Town & Country Planning Act 1990 (as amended)
Town & country Planning (Development Management Procedure) (England) Order 2015

Single storey extension as annex for elderly relative (resubmission following AW/208/17/HH).

31 Queens Fields West Aldwick

Proposed Ground Floor

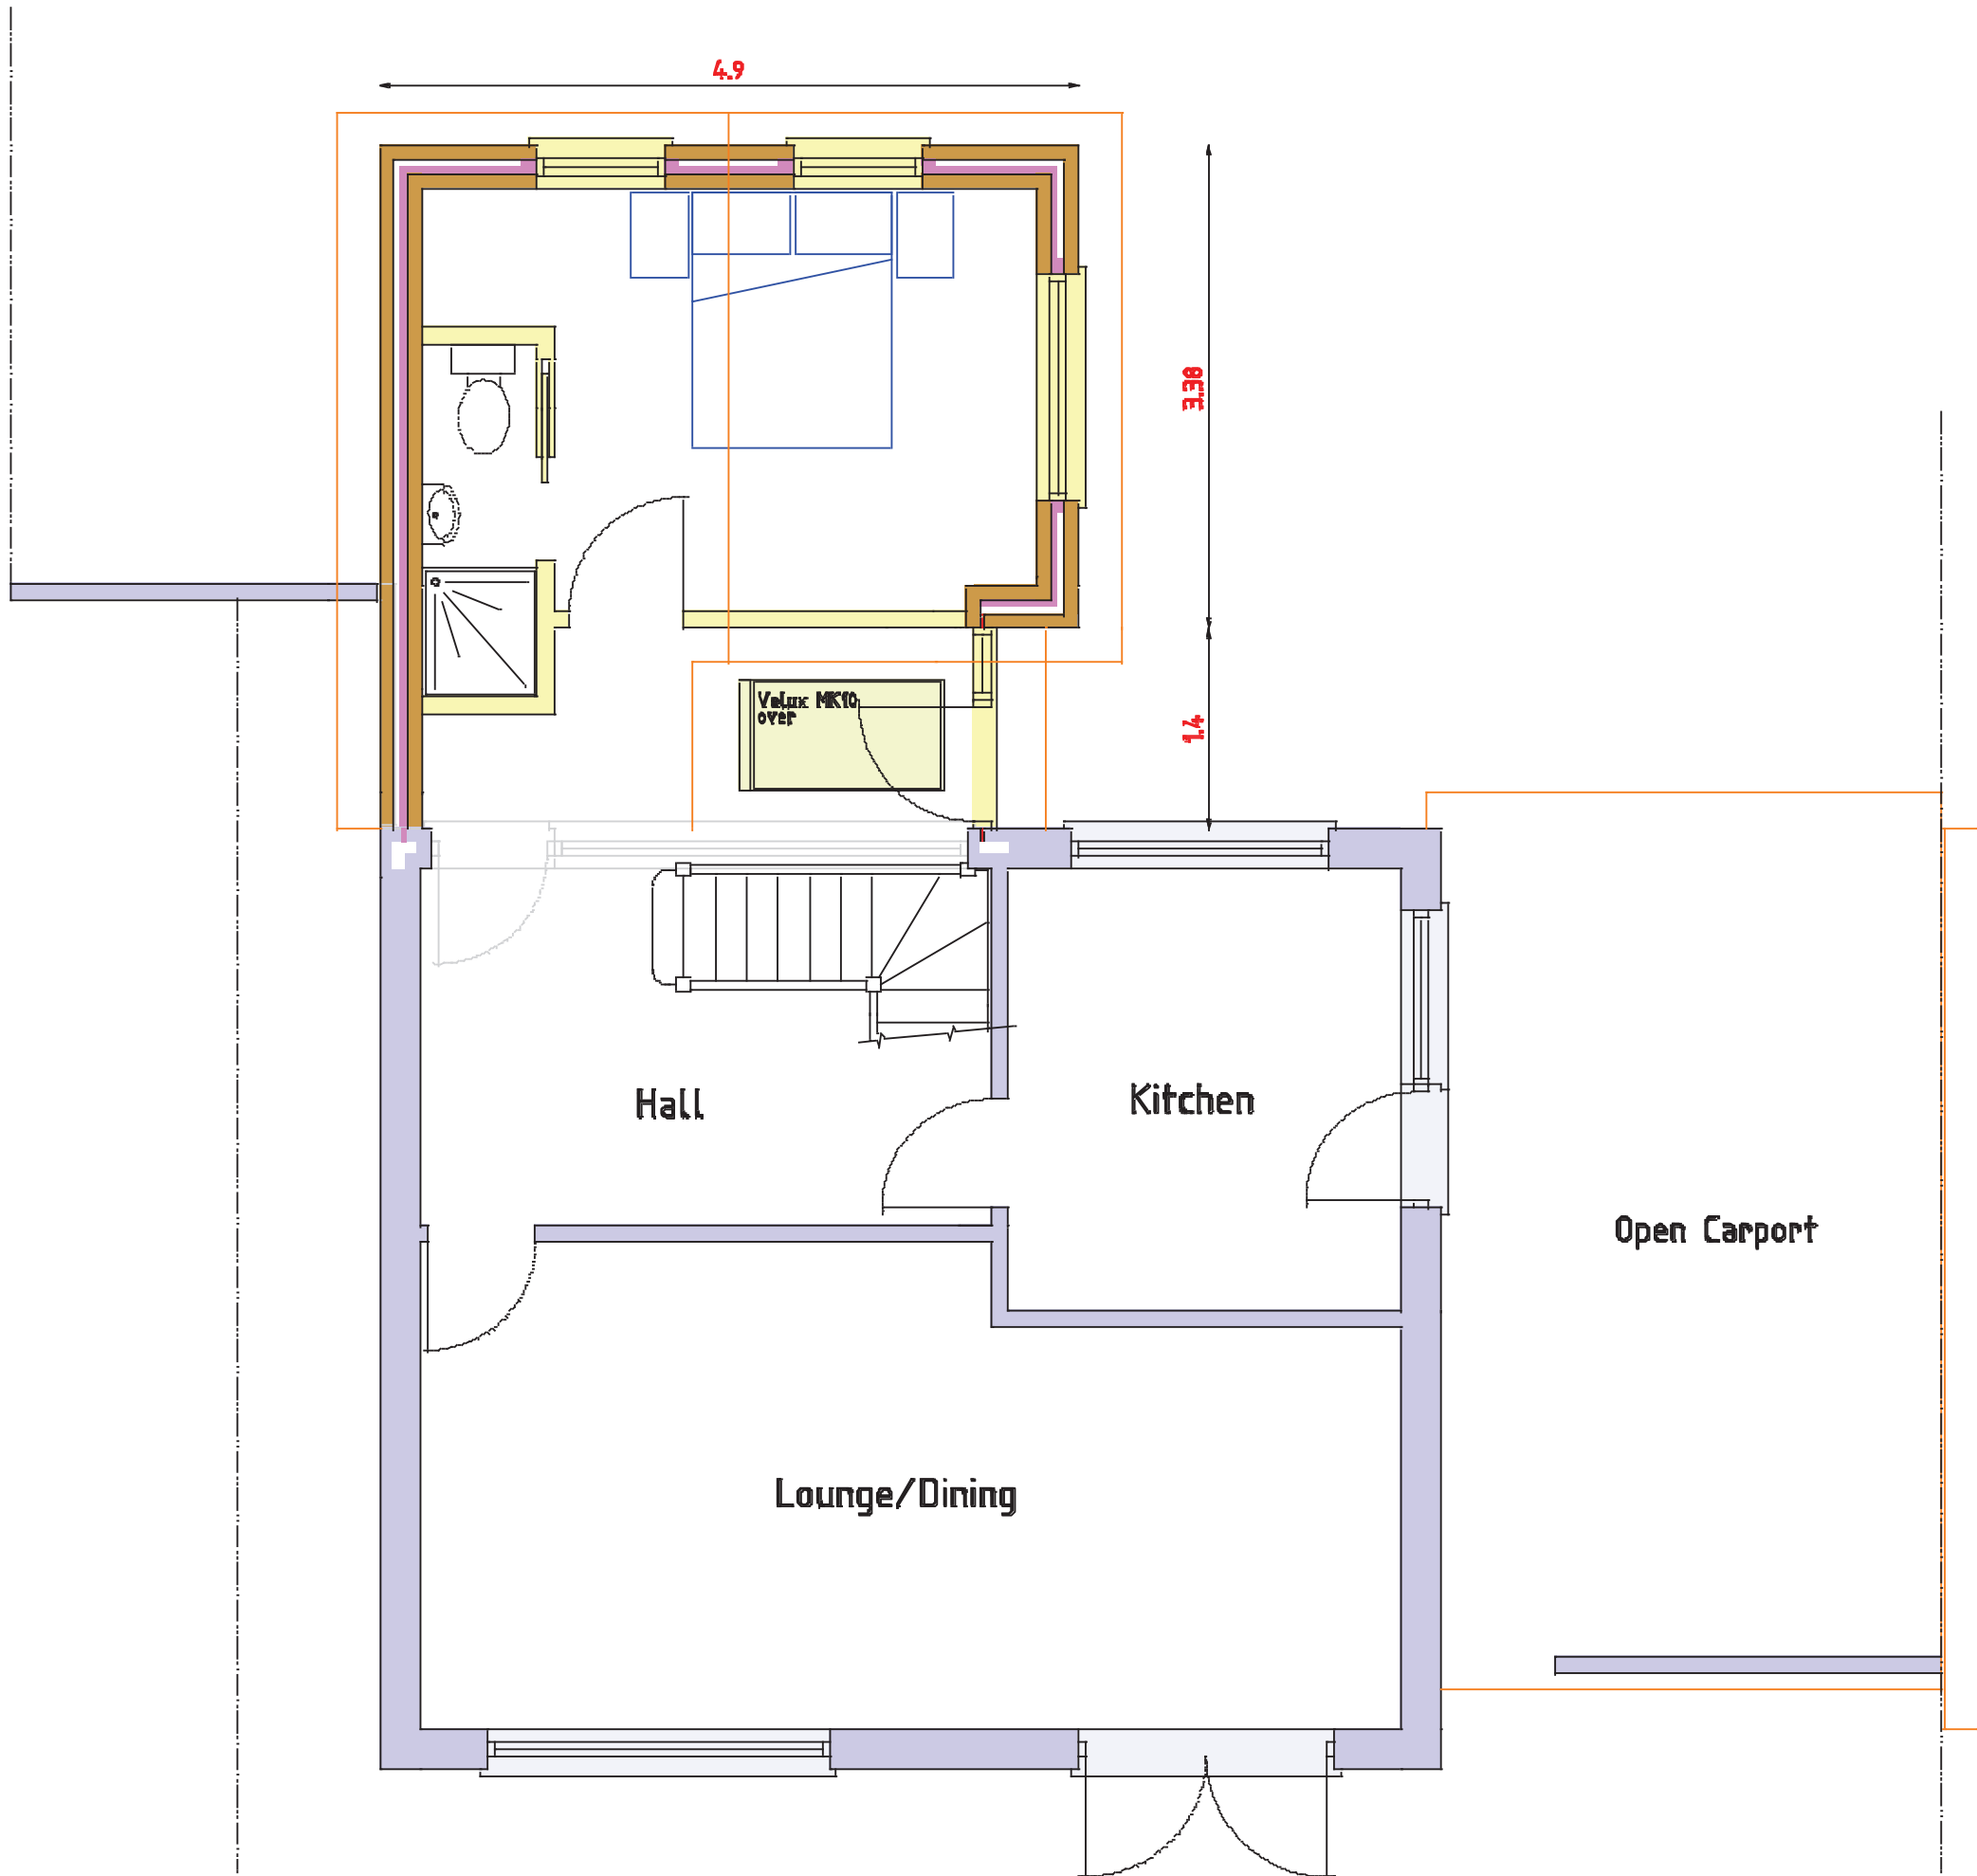
The new plans are no better than the previous application. An extension to the front of the property of such proportions will completely be at odds with the buildings in the area.

Aesthetically the extension will be a complete eyesore, it will take up almost all the front garden. I see there is a garage to the side of the house. Converting the garage would look much better. Please, we cannot allow such an extension at the front of the property. This is supposed to be an open plan style estate, with such huge front extensions, if allowed, the estate would not be the attractive estate it once was.
